Our Ref: TR040011

Planning Act 2008 – Section 51

Application by North Somerset District Council for an Order Granting Development Consent for the Portishead Branch Line – MetroWest Phase 1

Advice following issue of decision to accept the application for Examination

Figure N-25: Pre Development, 75year return period event in 2115 ,Tidal

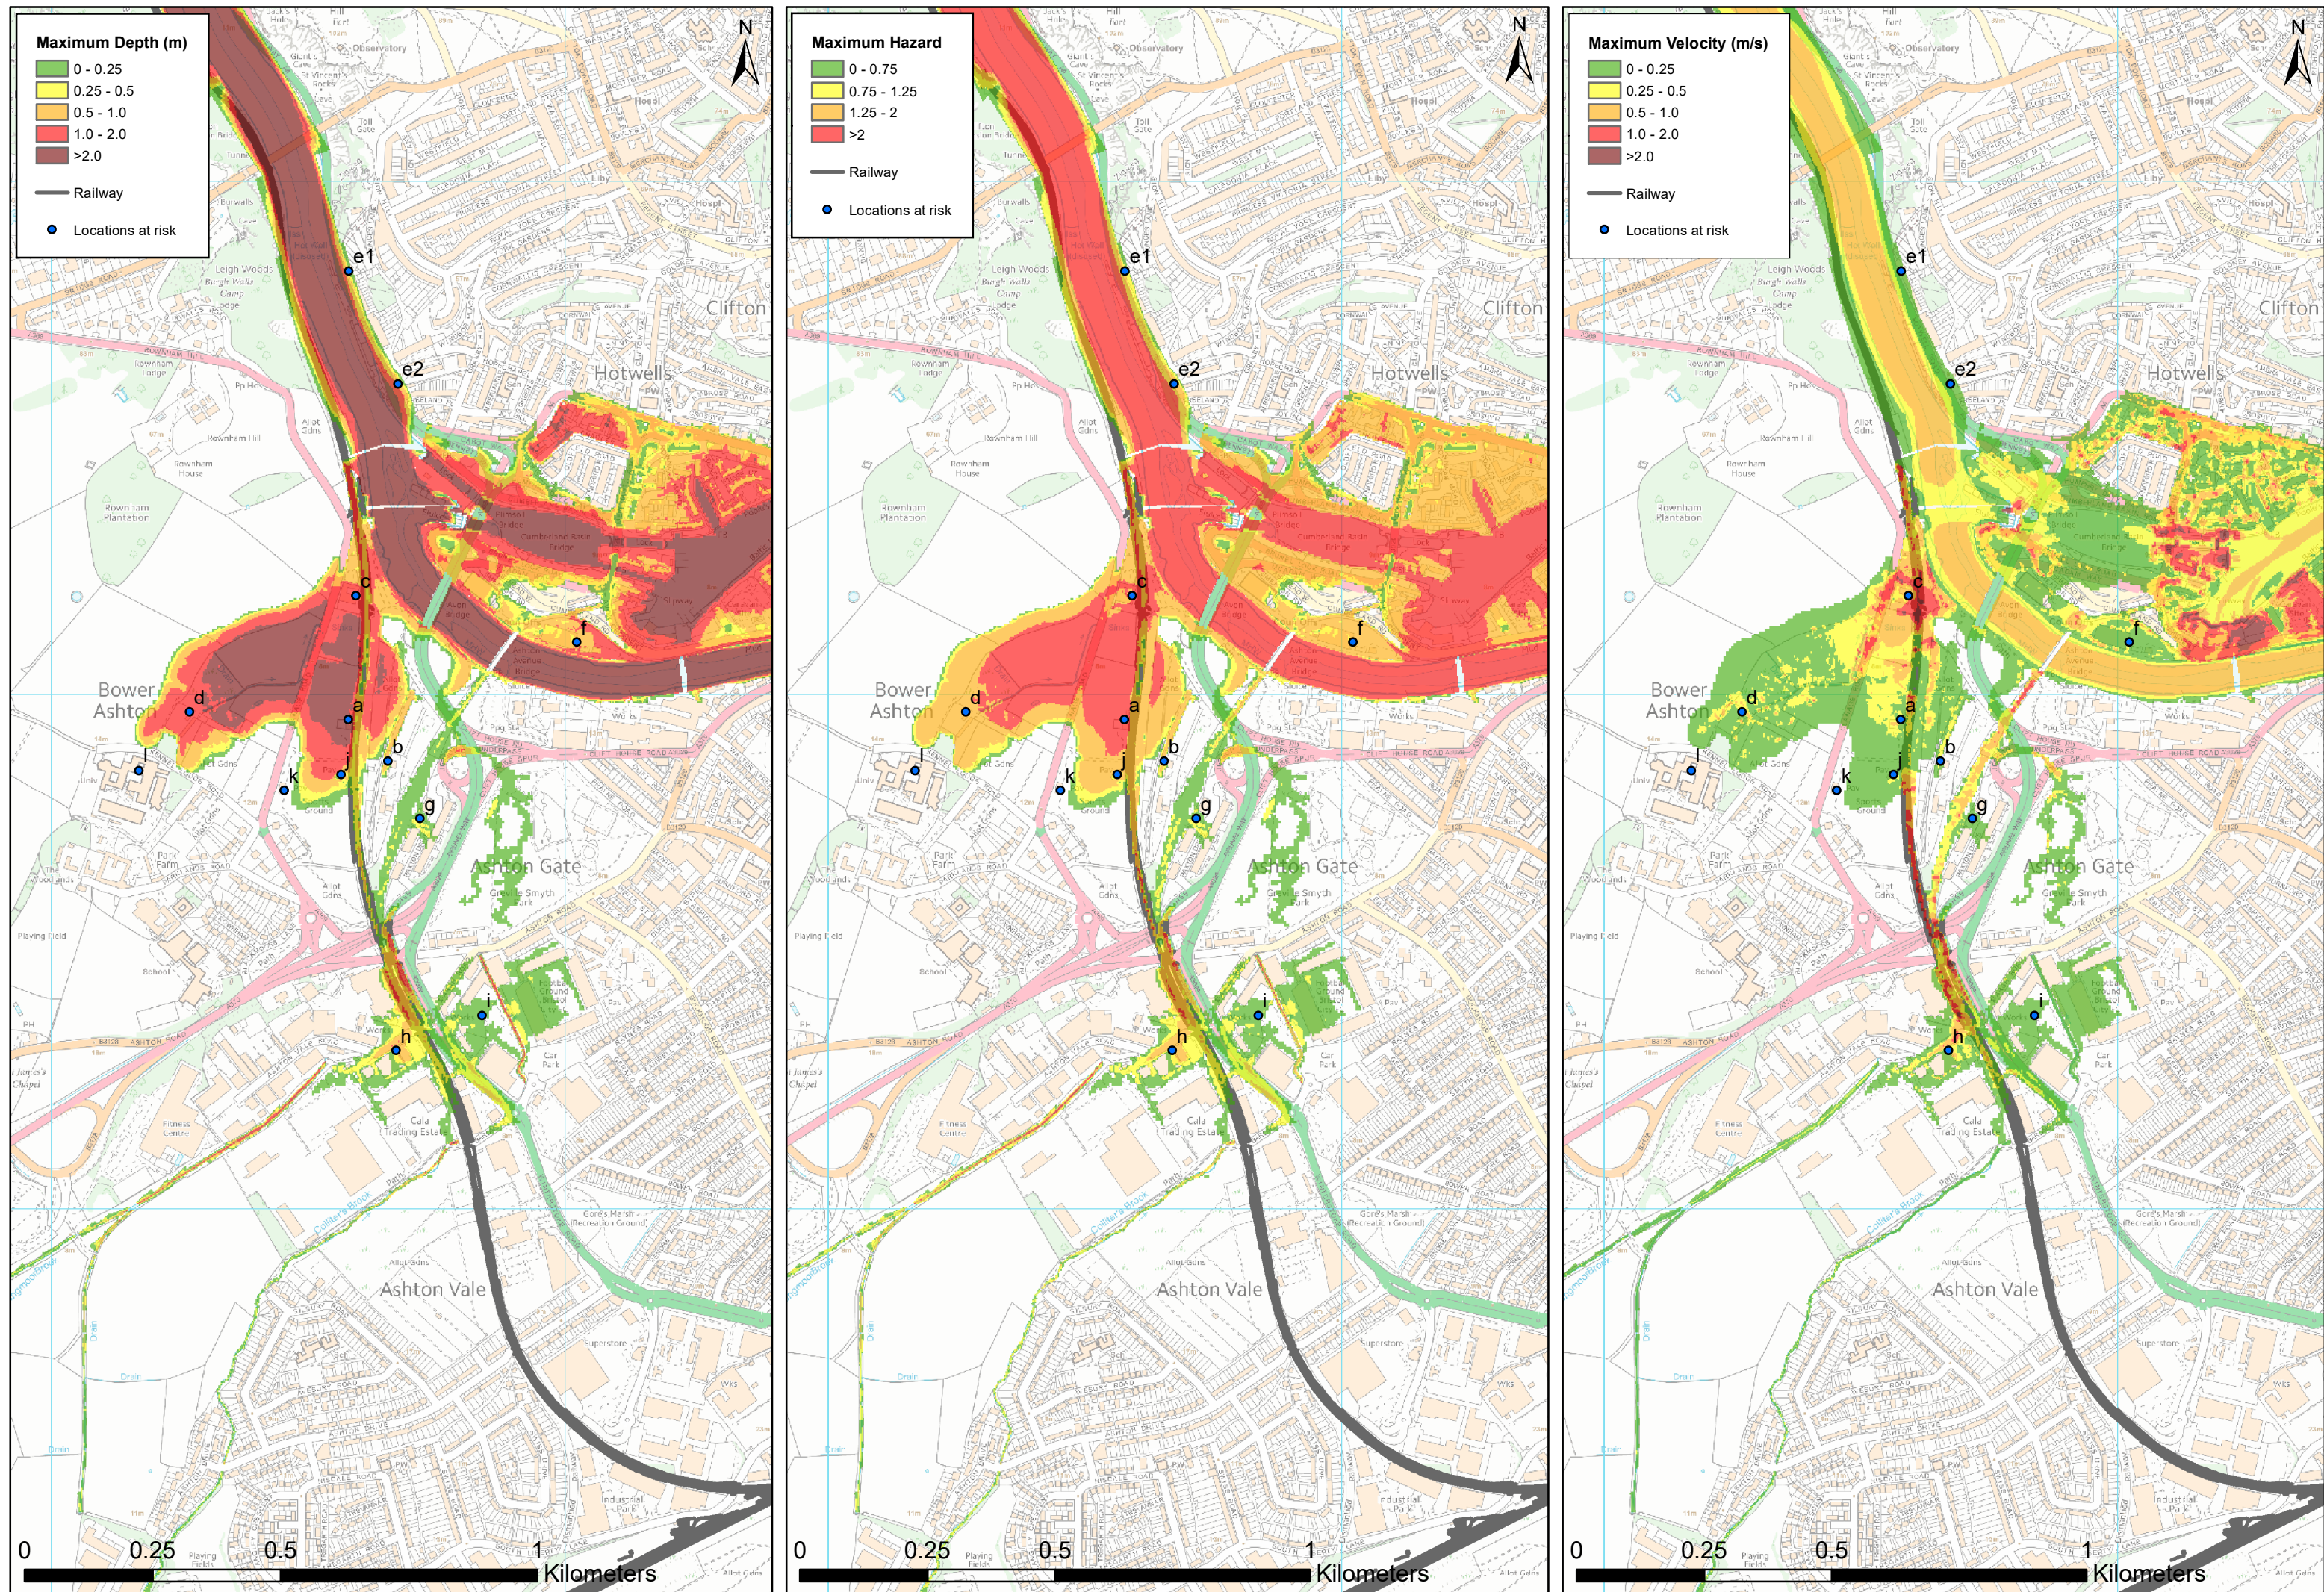
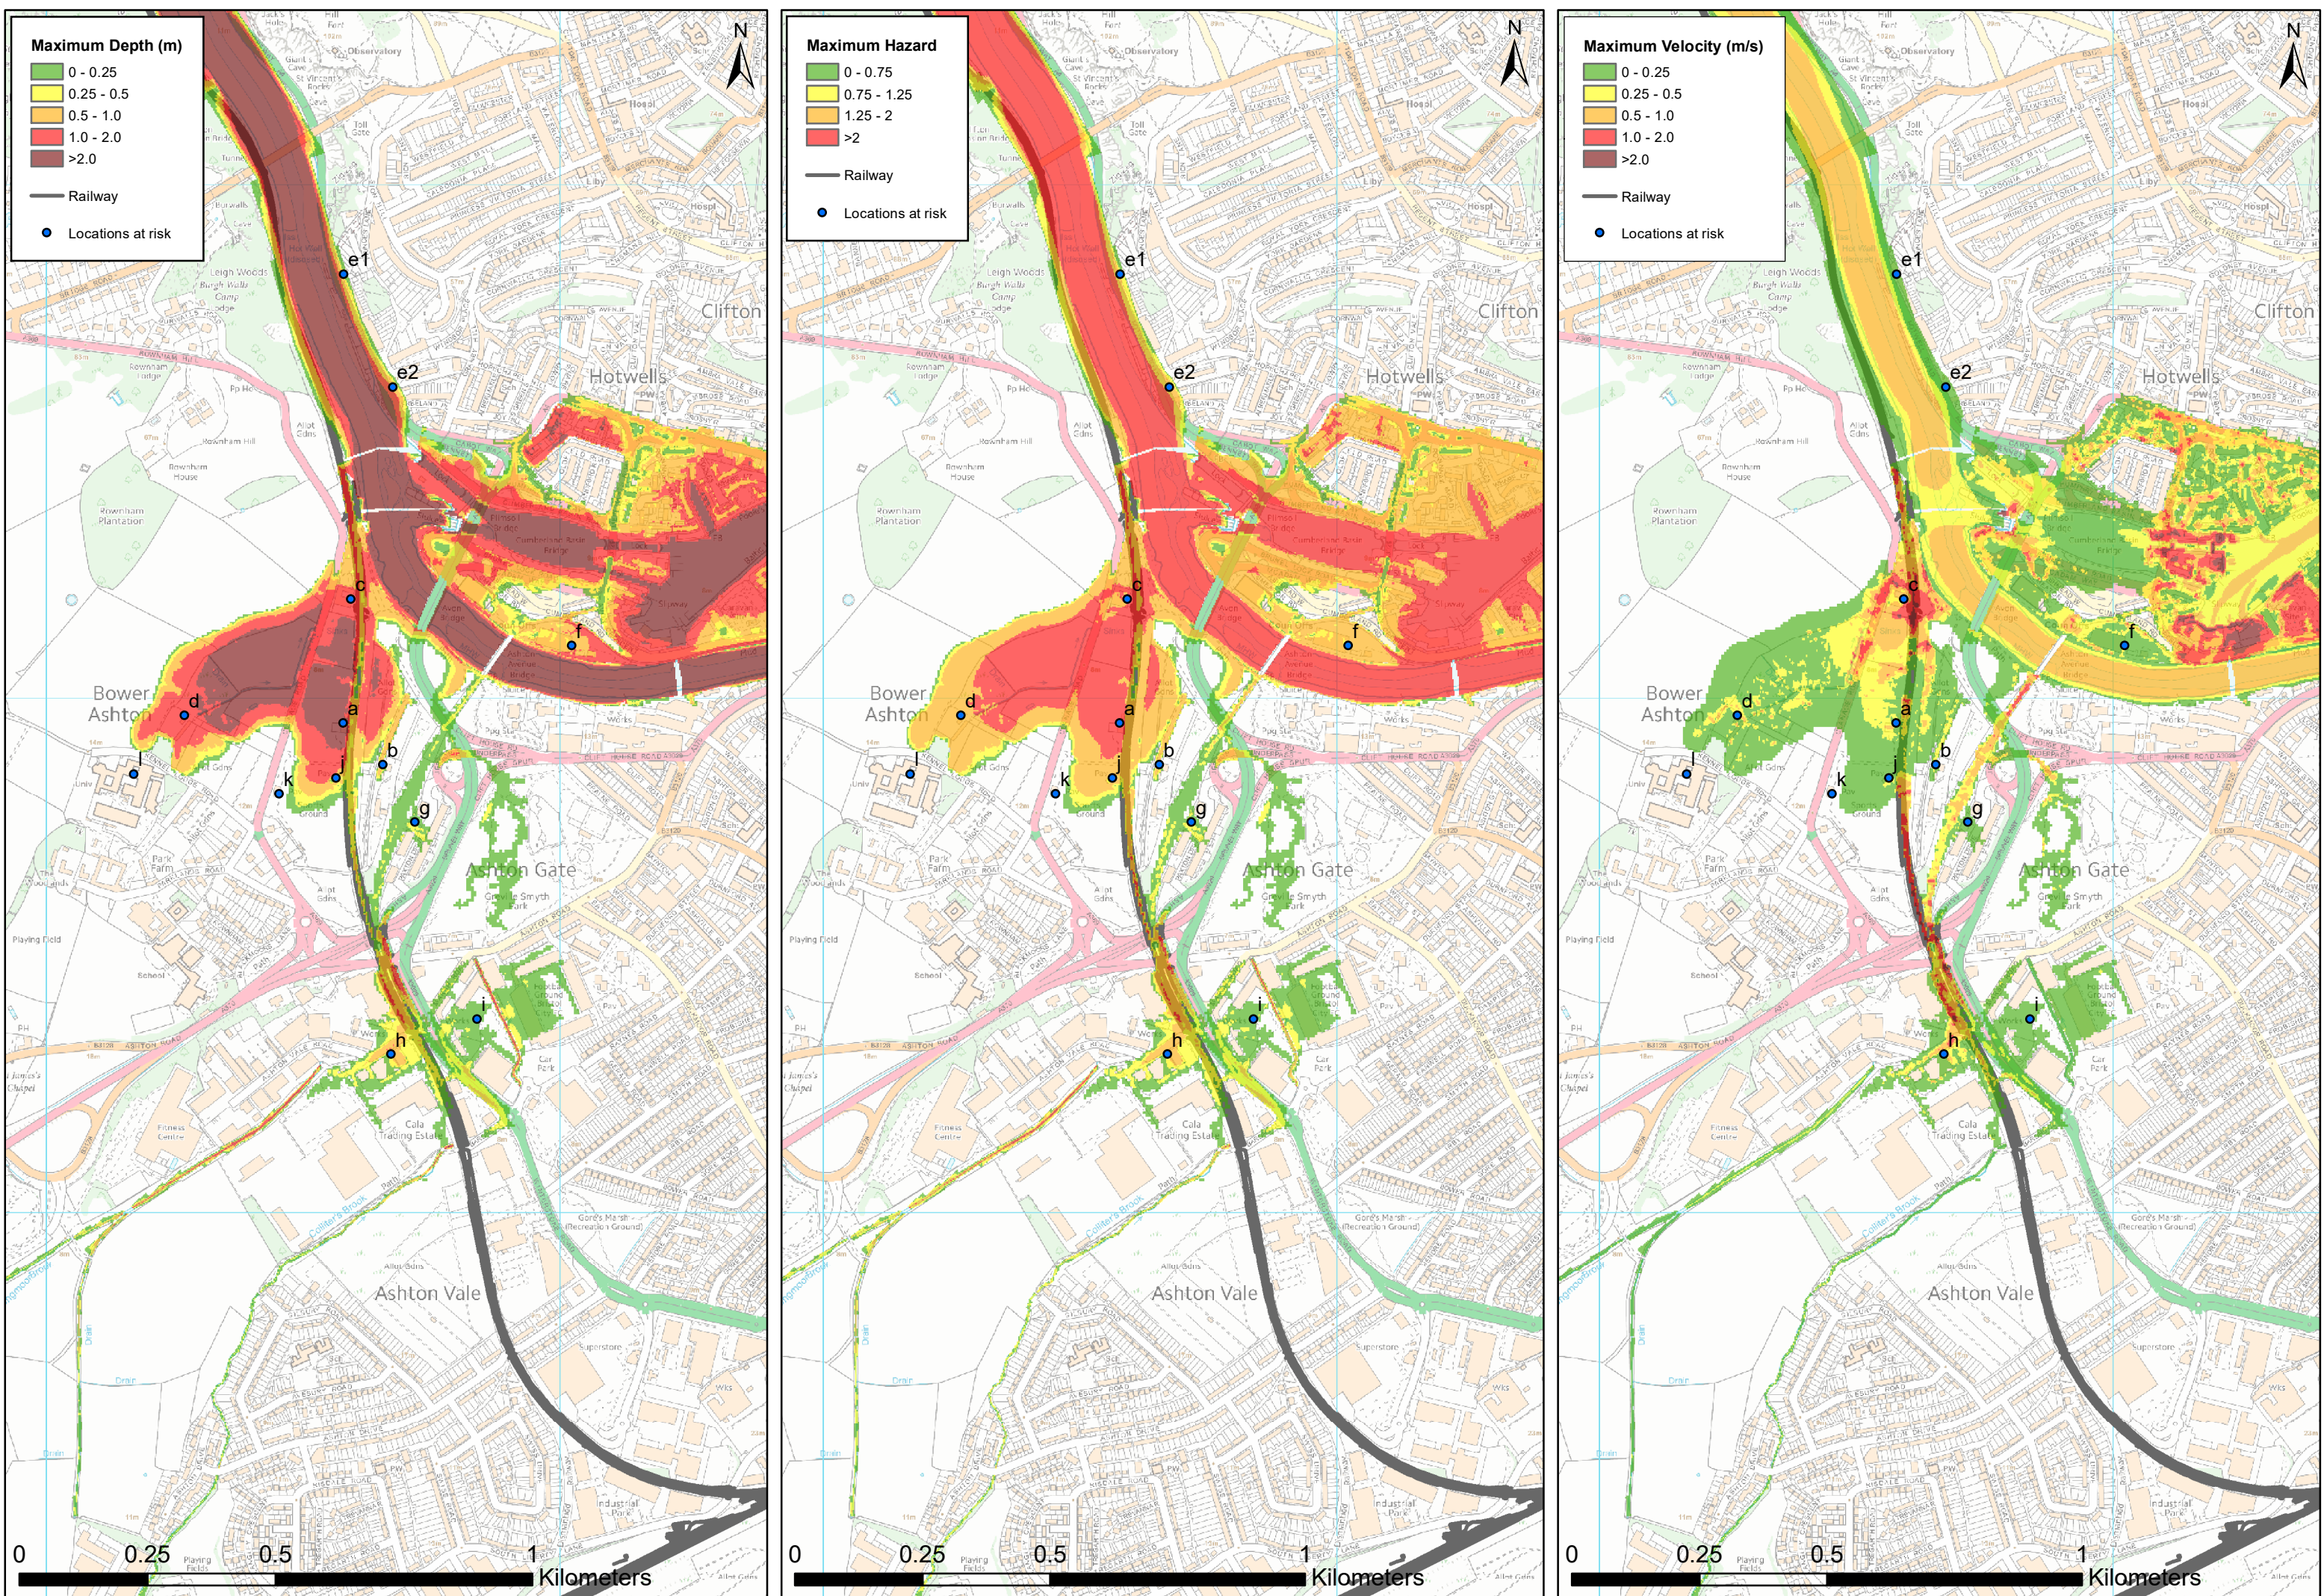
At Bower Ashton - the simulation of impacts from River Avon tidal flooding indicates that this section of the operational NSIP would experience tidal flood events once every 5 to 10 years for the assessment year (taken to be 2015) and more than once a year on average in the future (scenarios 2075 and 2115) (taking into account climate change, including sea level rise, into consideration). In preparation for the examination the Inspectorate seeks to understand the extent to which the application of the revised climate change allowances may (or may not) affect the findings in this regard. In particular, whether such detail would result in anticipated flood events at more frequent intervals and at earlier points in the design life of the Proposed Development.
